CITY OF ALBUQUERQUE

July 7, 2015

**RE: Sandia Area Credit Union and Starbucks, 11301 Montgomery Boulevard
Grading and Drainage Plan
Engineer's Stamp Date 7-01-2015 (File: F22-D002)**

Safca & Starbuc GRADING AND DRAINAGE PLAN	DRAWN BY DEM DATE 8-14 Safca & Starbuc 000 Planning
		SHEET # 1 of 1 JOB # XXXXX
3/17/15 DAVID SOULE P.E. #14522

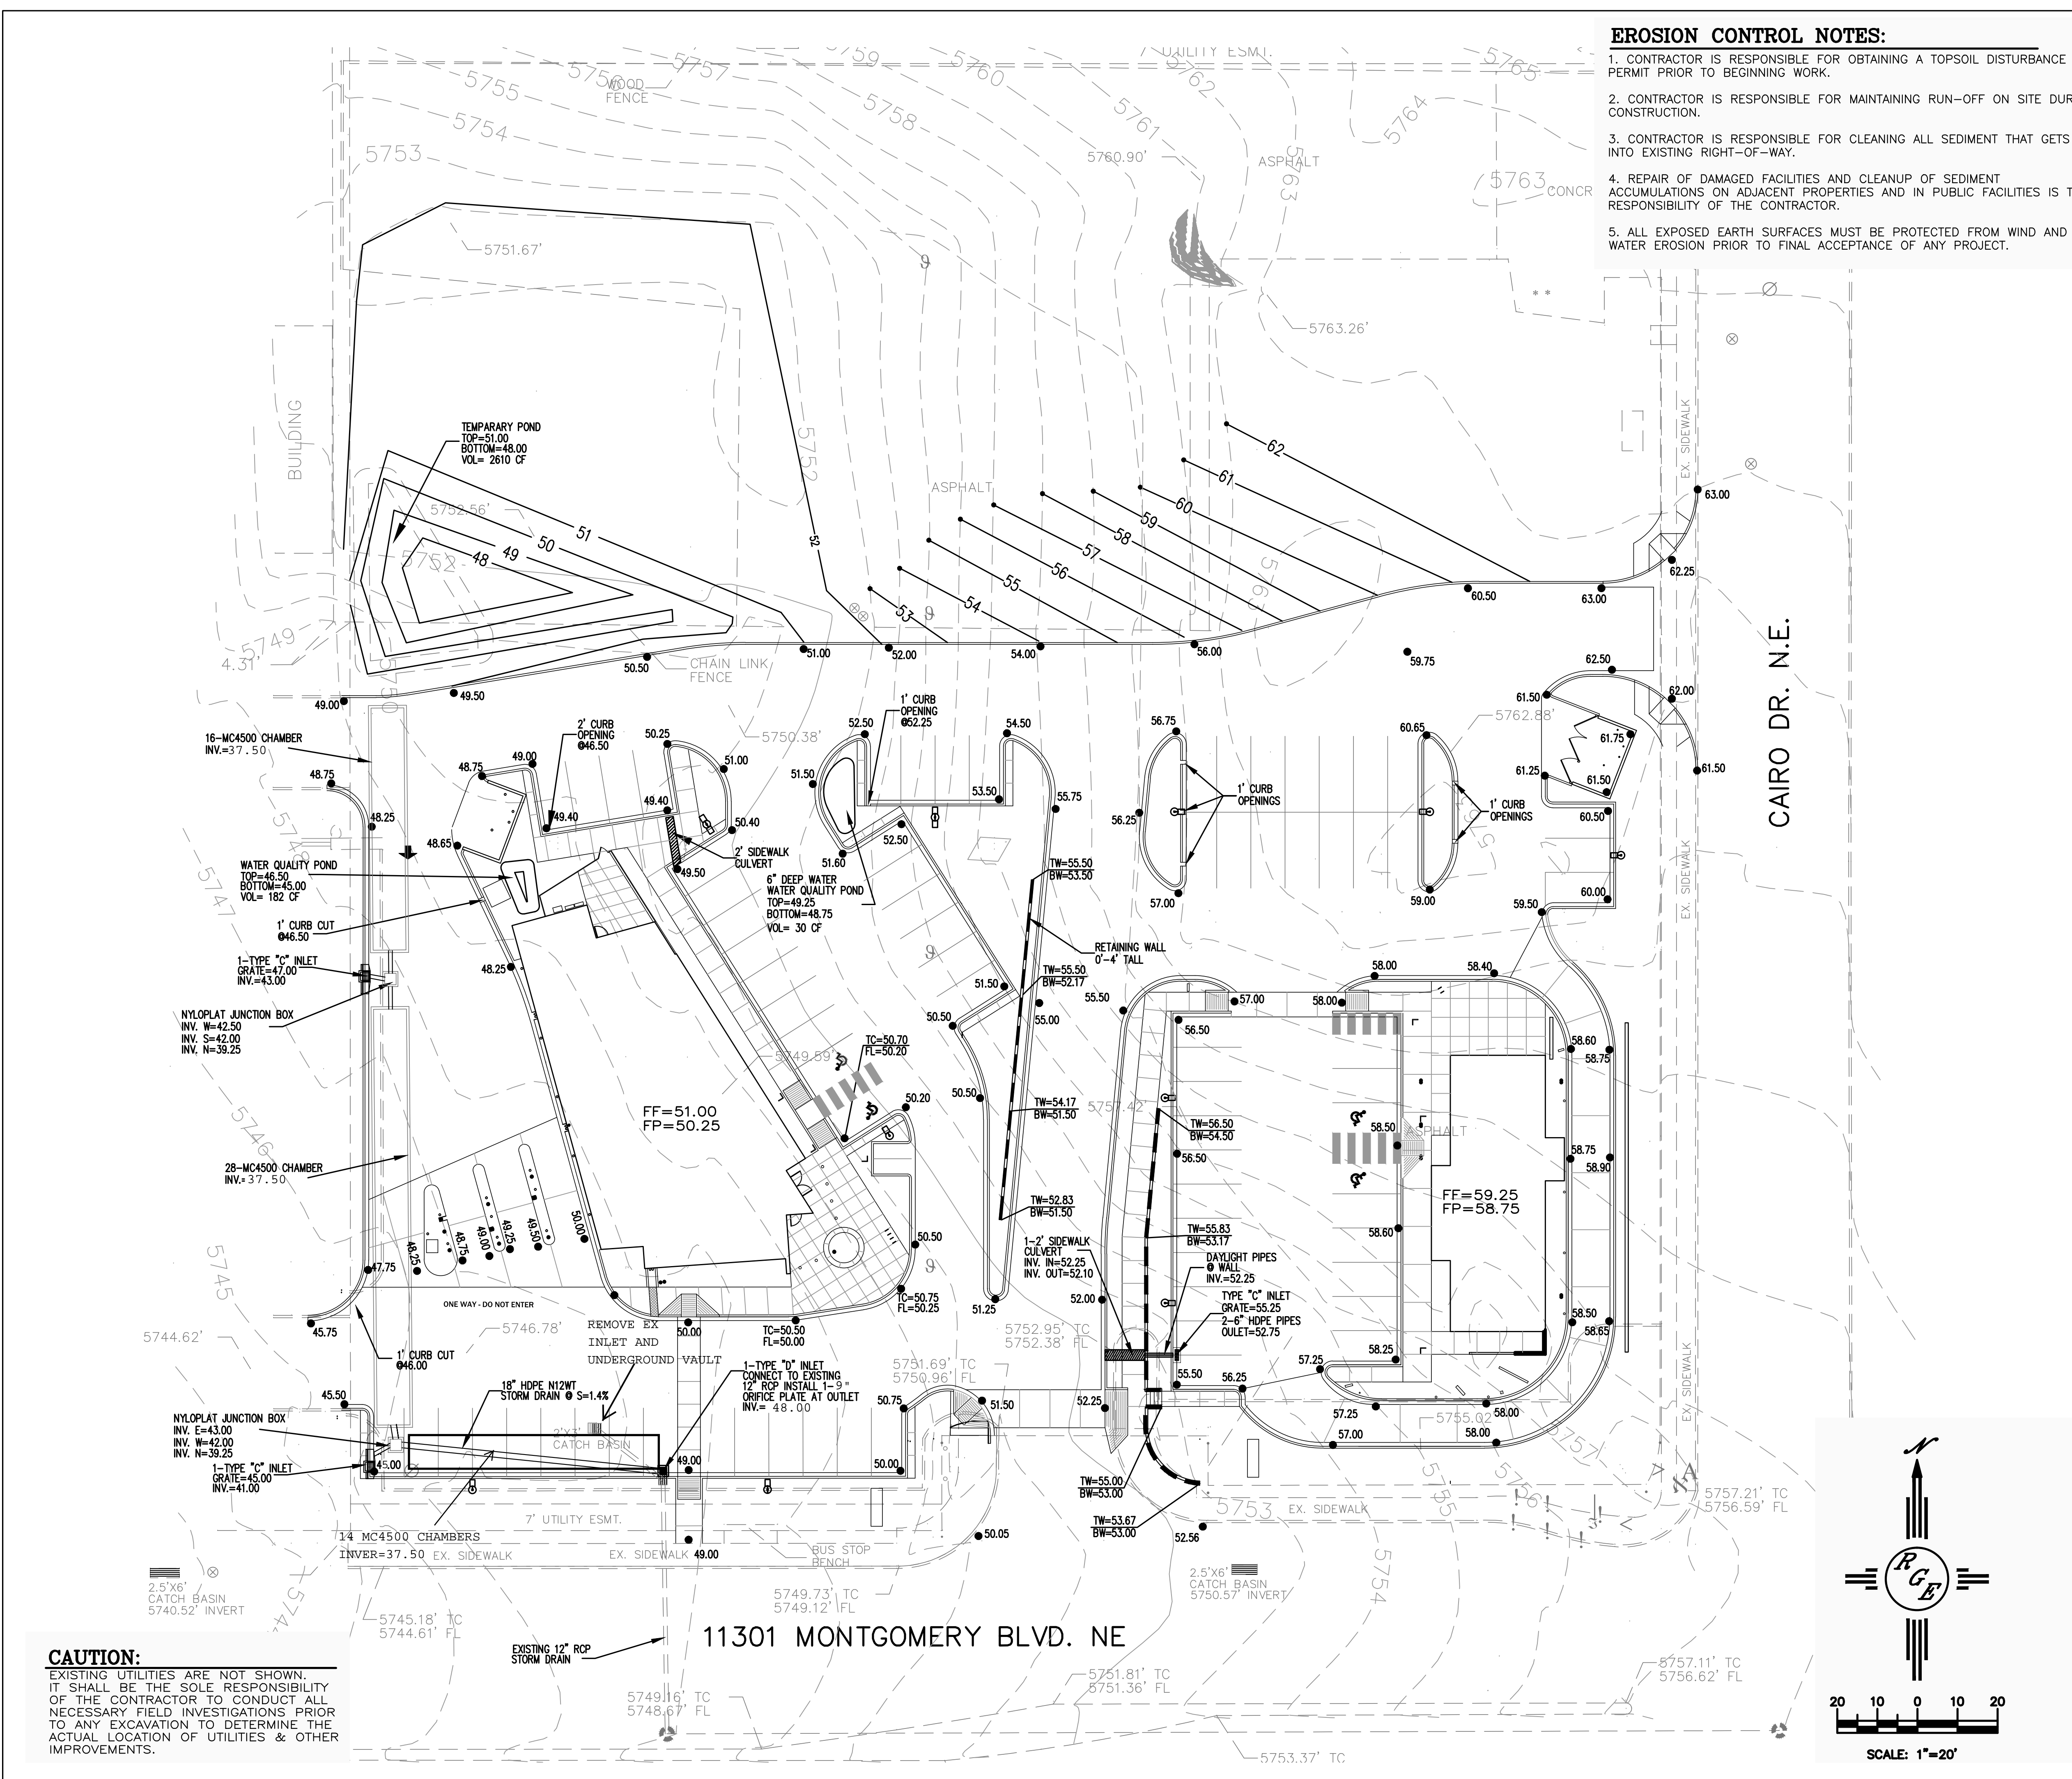
1. An approved plat showing the proposed storm drain easement is needed prior to construction.
2. A storm drain easement must be shown on the Engineer's certified plan prior to Certificate of Occupancy.

1. We are adding this easement to the plat, the surveyor is preparing the second sheet
It will be emailed to you when completed and submitted by Friday for drb consideration.
